REPORT UPDATE

Application No: R/181/15/PL

Recommendation Report for Planning Permission**REF NO:** R/181/15/PL**LOCATION:** Land to the south of The Tiled Barn
Station Road
East Preston**PROPOSAL:** Erection of 2 No. 3 bed dwellings, demolition of existing garage & shed & erection of new car port. Resubmission following R/305/14/PL. This application affects the character & appearance of the Station Road Conservation Area.**SITE AND SURROUNDINGS**

DRAWN T Zajac	DATE Feb 2015	PROJECT NO. 22451
ENGINEER G Waller	CHECKED GW	DWG NO. 101
SCALE 1:250 @ A3		REV B

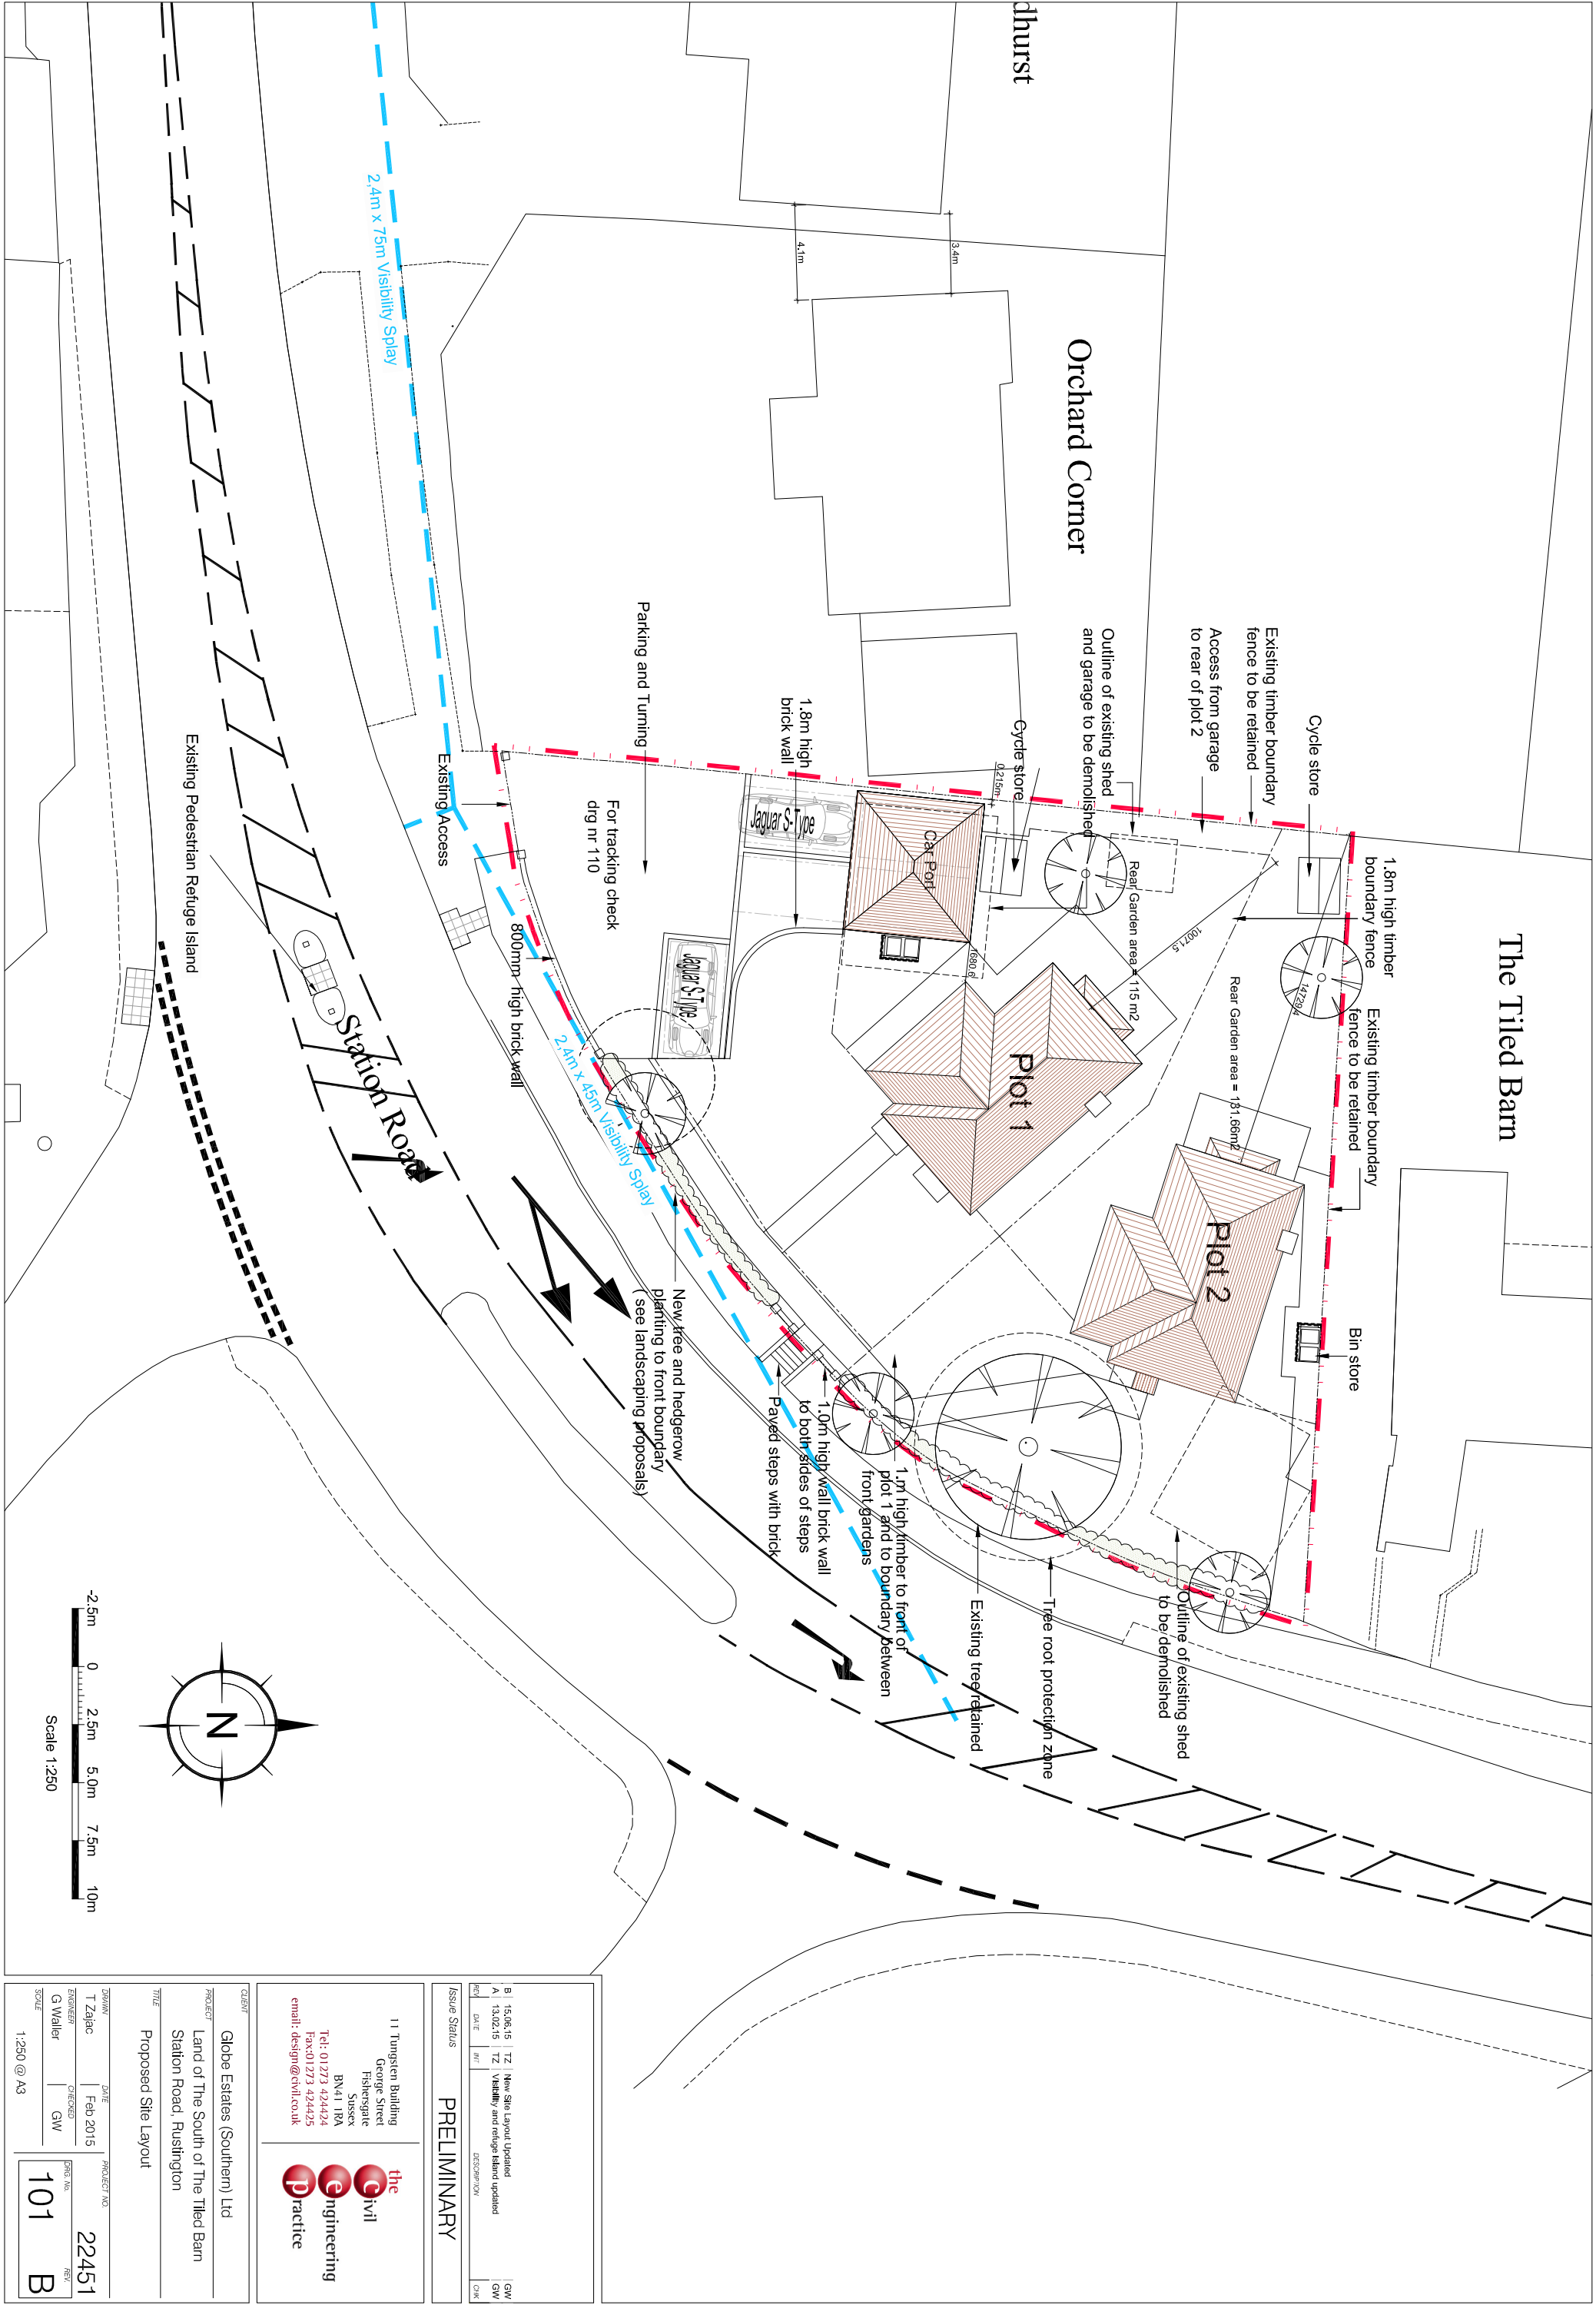
The applicant has provided plans showing the visibility splays that can be achieved from a 2.4m set back from the existing access point. The LHA are of the opinion that these are acceptable given the 30mph speed limit on Station Road and the fact this is an existing access where visibility is being improved by the applicant reducing the height of the boundary fencing/wall and removing the gates. The boundary wall either side of the access should be no more than 0.8m in height.

The plans and swept path analysis for the proposed parking arrangements and turn on site are considered acceptable, allowing vehicles to exit onto Station Road in forward gear. It was observed that an above average car size has been used in the supplied plans.

The LHA would advise that the access drive be constructed of a bound material, if it is to be constructed from shingle, this may result in material being dispersed onto Station Road affecting the surface of the road. The applicant should provide a gravel trap or area of block paving, or other bound material, at the point of access onto Station Road on land within the applicant's control.

Rev A Existing tree adjacent to parking area (T9) shown to be retained Sept 2015
REVISION

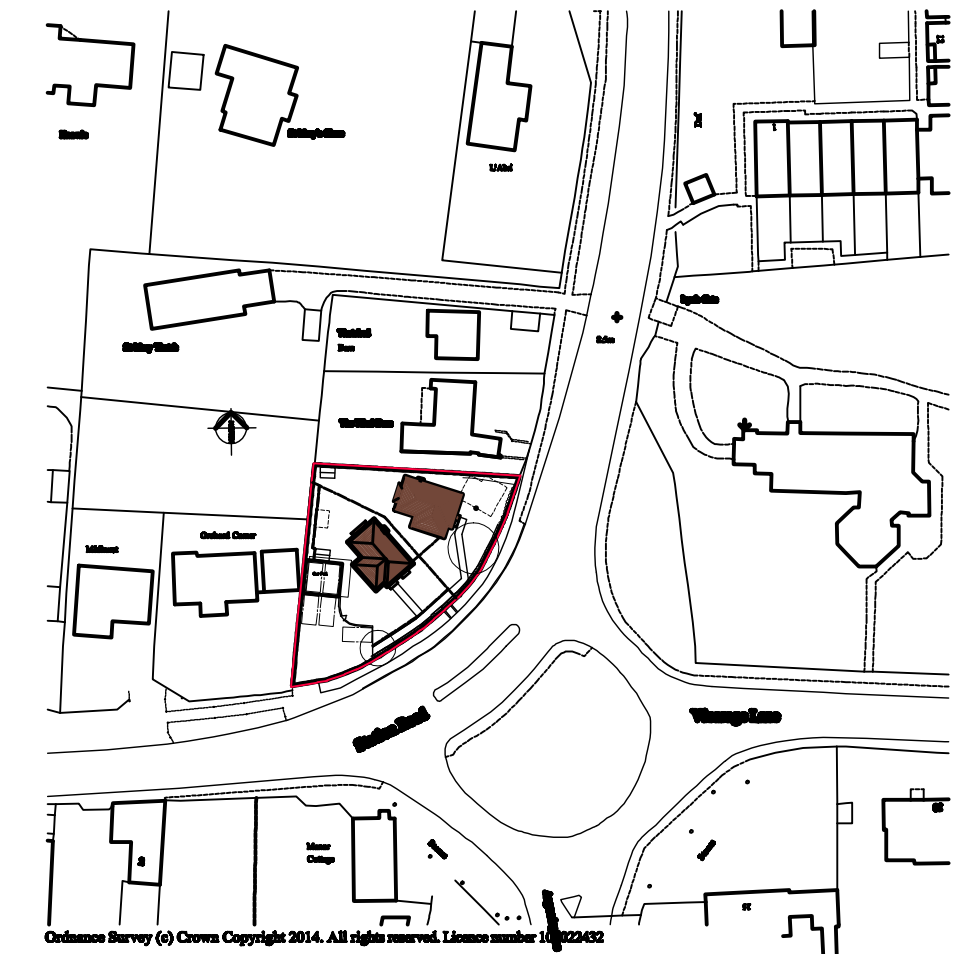
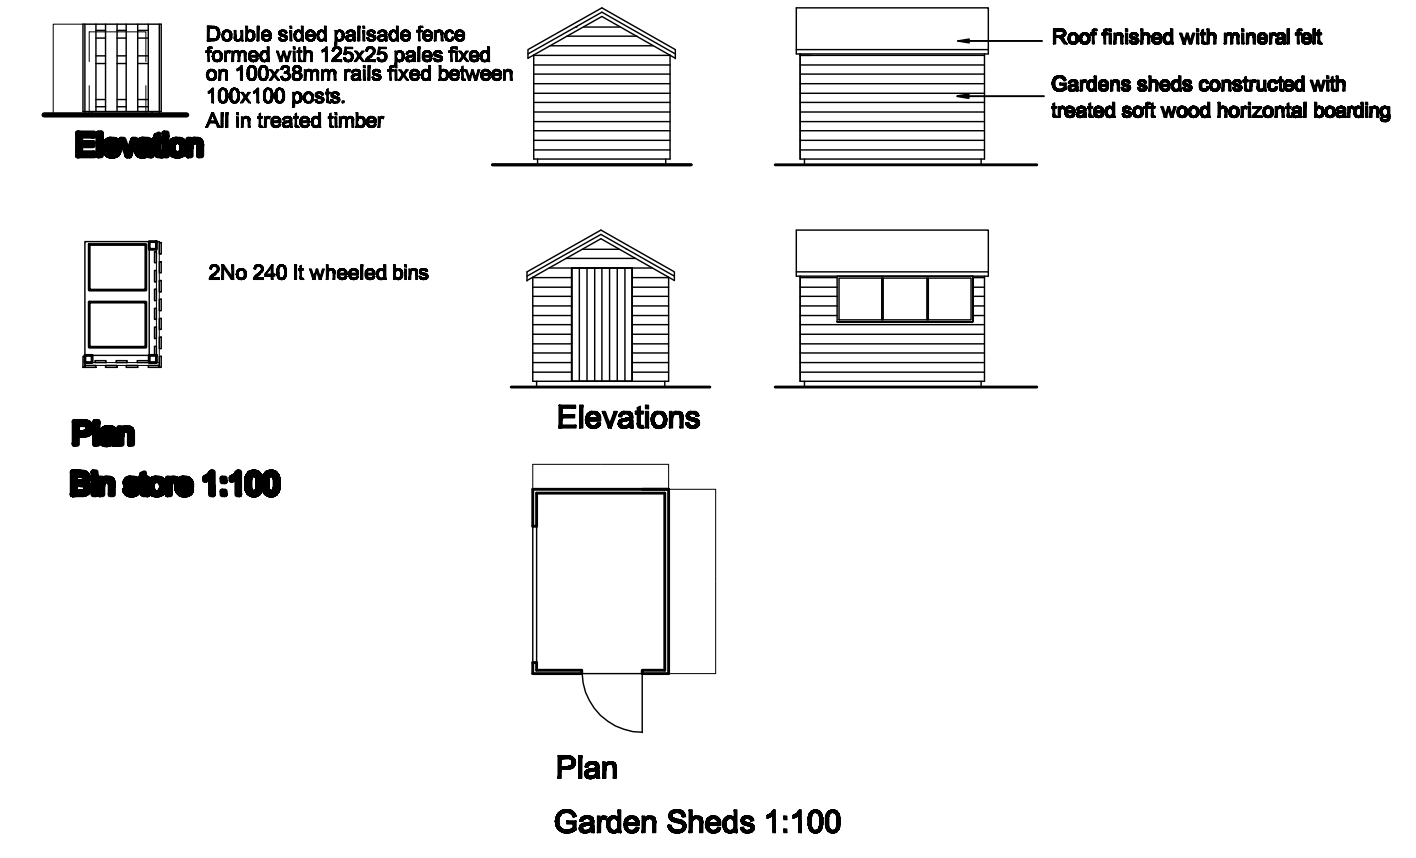
A revised block plan has been submitted showing the yew tree which is now the subject of a provisional Tree Preservation Order as retained and an additional street scene plan has been provided to illustrate the height of the proposed dwelling in relation to The Tiled Barn. Accordingly the plans condition has been amended to refer to the substitute plan, not the original and the additional plan.

If T9 is retained under TPO, alterations would have to be made to the submitted application to ensure damage is not inflicted. This would include suitable RPA/tree protection for the duration of the construction process. Also alterations are likely to have be made membranes/surfacing to the west of T9, where the proposed parking and turning area is due to be placed, as this area is likely to overlap with the RPA of T9.

Comments noted. Requested conditions have been imposed. Tree T9 is now the subject of a provisional Tree Preservation Order.
